Administrative Authorization Application

PROJECT NAME: FEDEx FREIGHT - ABOVE GROUND STORAGE TANK

INSTALL A 12,000 GAL. ABOVE GROUND STORAGE TANK

Administrative Authorization Decision

FRIT & TERMINAL
 236 W. ... ST, PORTLAND, ME
 PROPERTY AS LOCATED SKETCH
 7-30-12

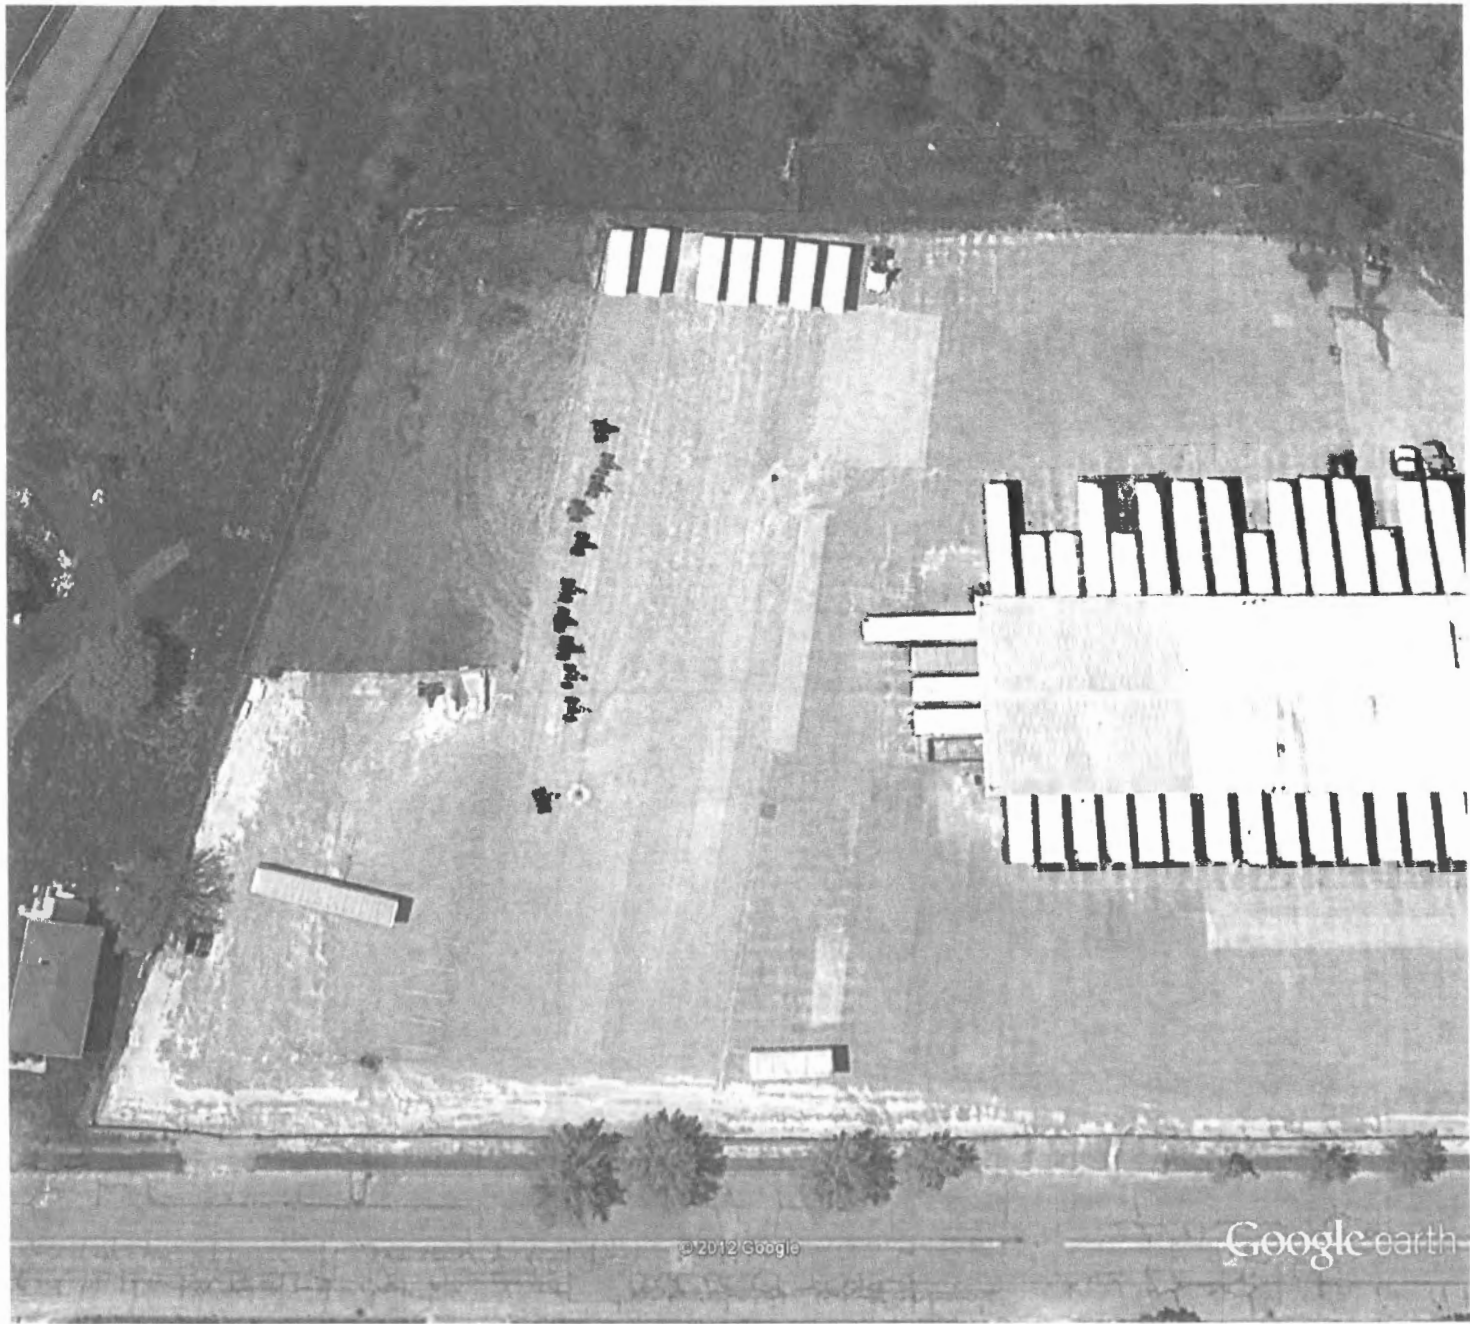
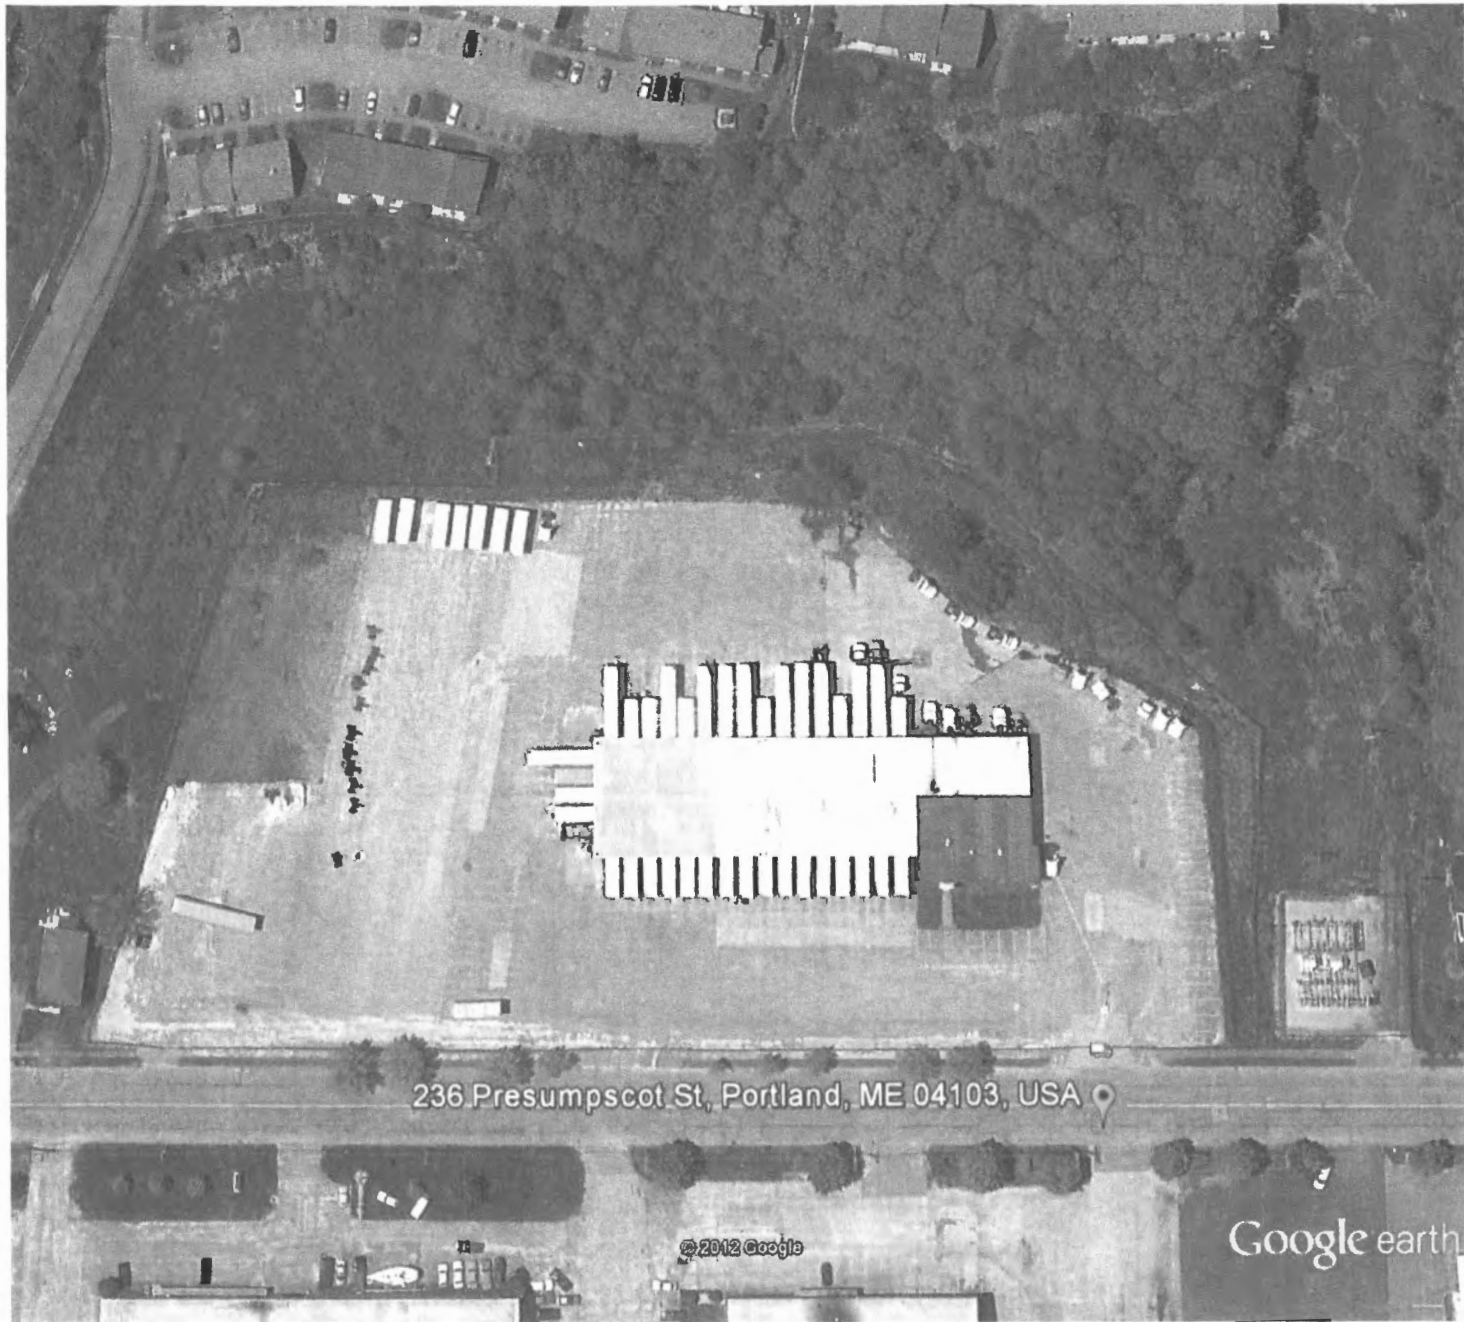
I don't see the site plan showing where on the site the tank is to be located. Could you forward it along?

For the planning review, I would like to know where on the site the pad and tank will be located (I see you have 3 options) and any other site improvements that may be proposed, such as bollards or screening of the tank. Also, could you please give me the volume of the tank and what will be stored in the tank. Lastly, does this require any permits from DEP?

I went to the site this weekend and took measurements from the building and from the fence lines. I have attached a sketch as well as two aerial photos of the site. I hope this answers your questions. Please let me know if you need anything else and I will do my best to get it for you.

As we discussed this afternoon while looking for the answers to your questions below I received a sketch which shows more concrete pad than I originally told you. I have attached a copy of the sketch for your review, it is labeled as "Fed Ex Tank 1A". This drawing also addresses your question about the bollards that are being added. No screening is proposed.

I have also attached an aerial photo which shows just the one option that was accepted by the owner regarding the tank location. I will get dimensions from the proposed tank location to the property lines on the front, back and side of the lot.

Proposed Fed Ex Tank Design
Portland, ME

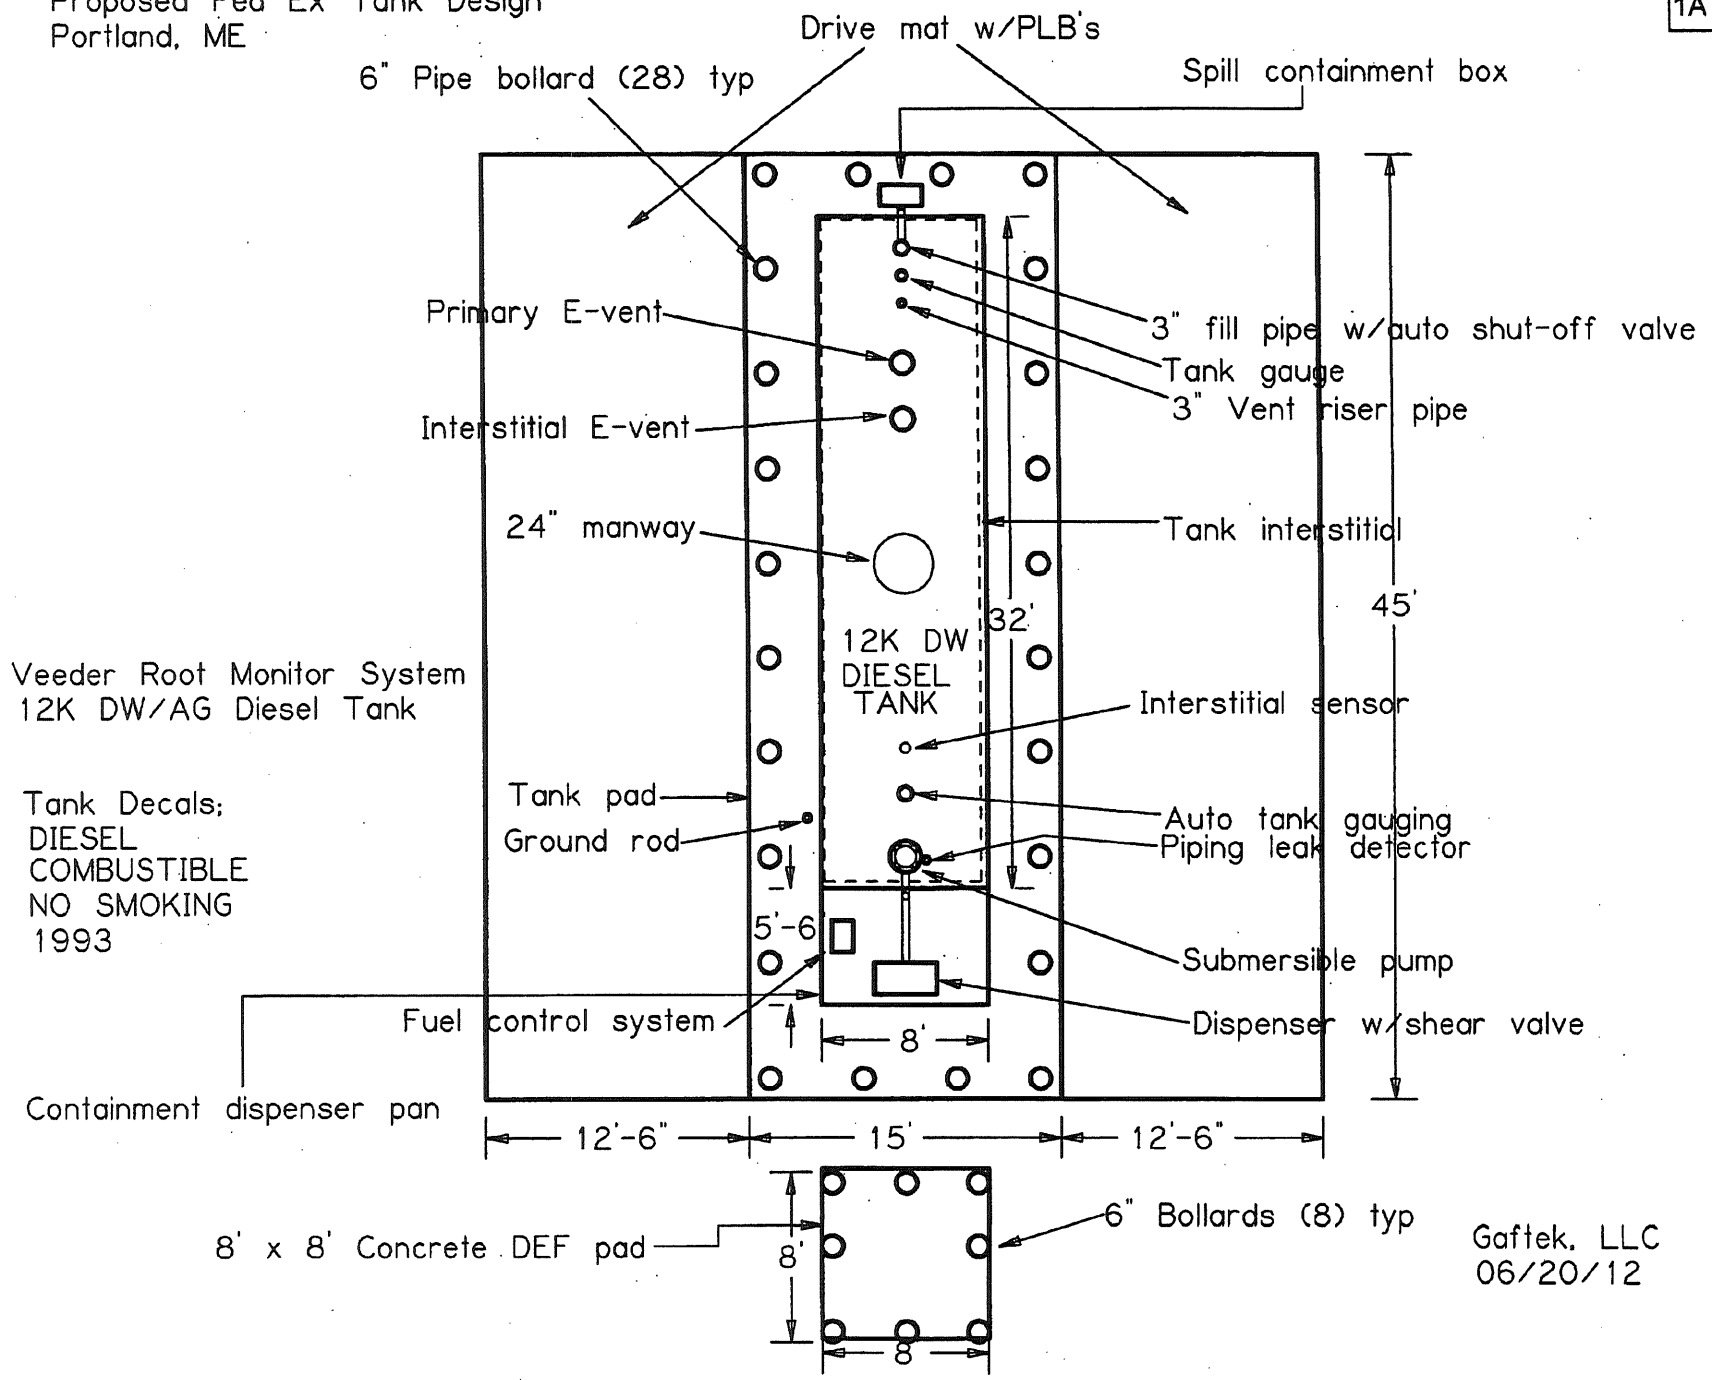
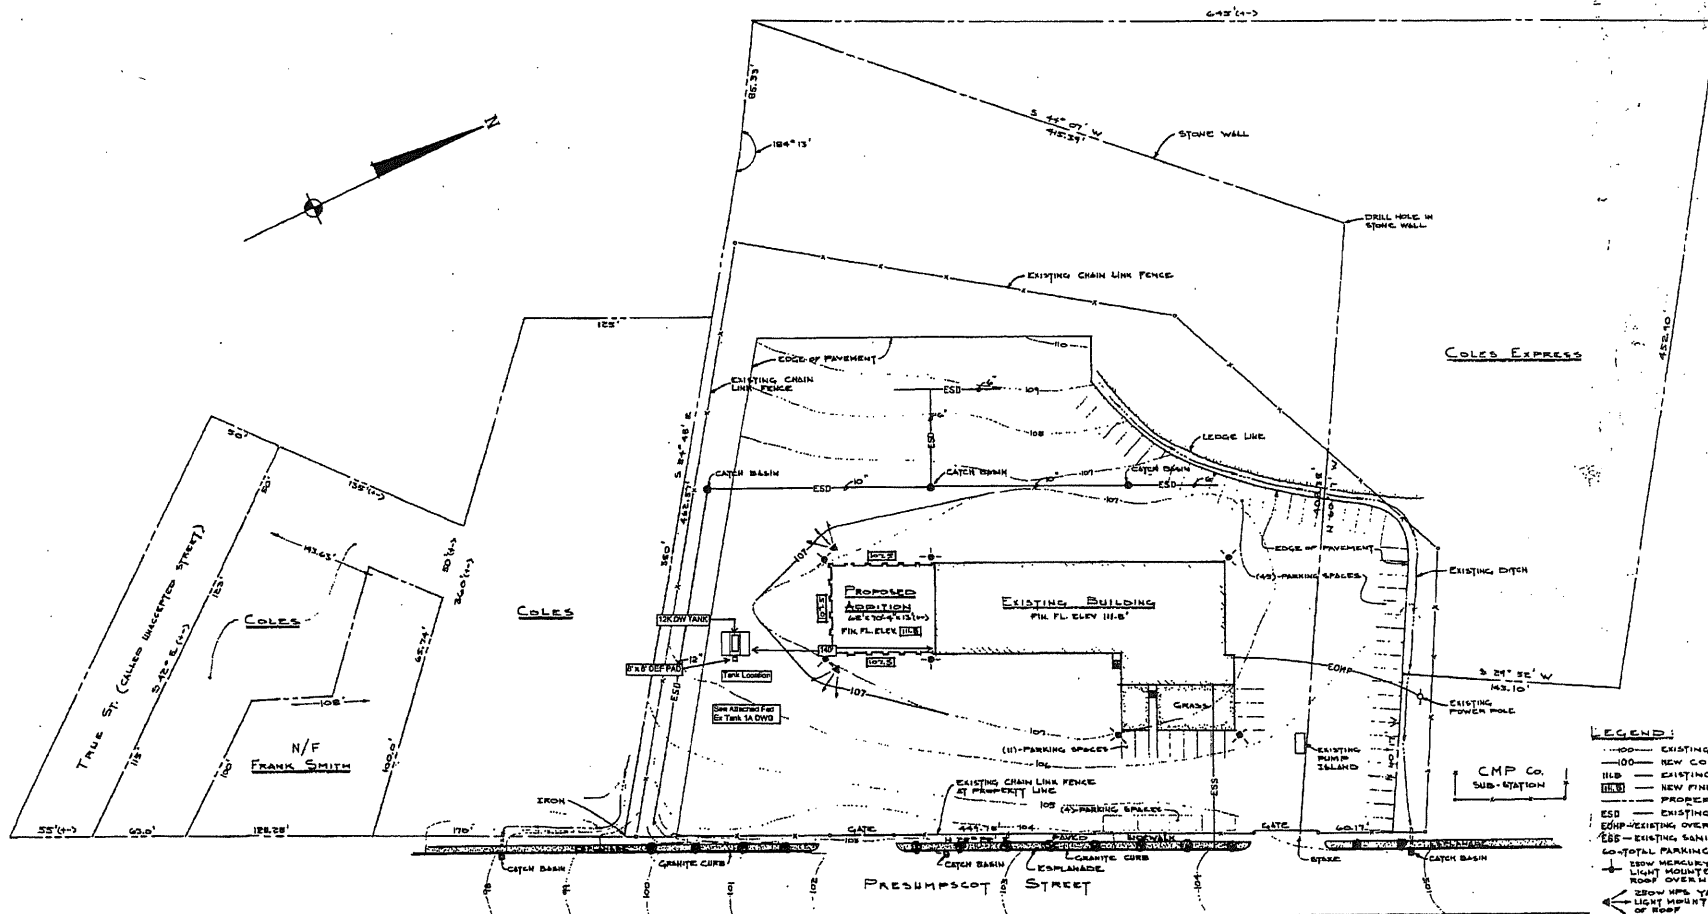
| c) Is the footprint increase less than 500 sq. ft.? | NO | The concrete pad replaces existing parking lot pavement. The pad is 15 x45 with the aprons 12'6' X 45 |

As we discussed, the location where the concrete pads are proposed is currently asphalt so we will not be adding any impervious surface.
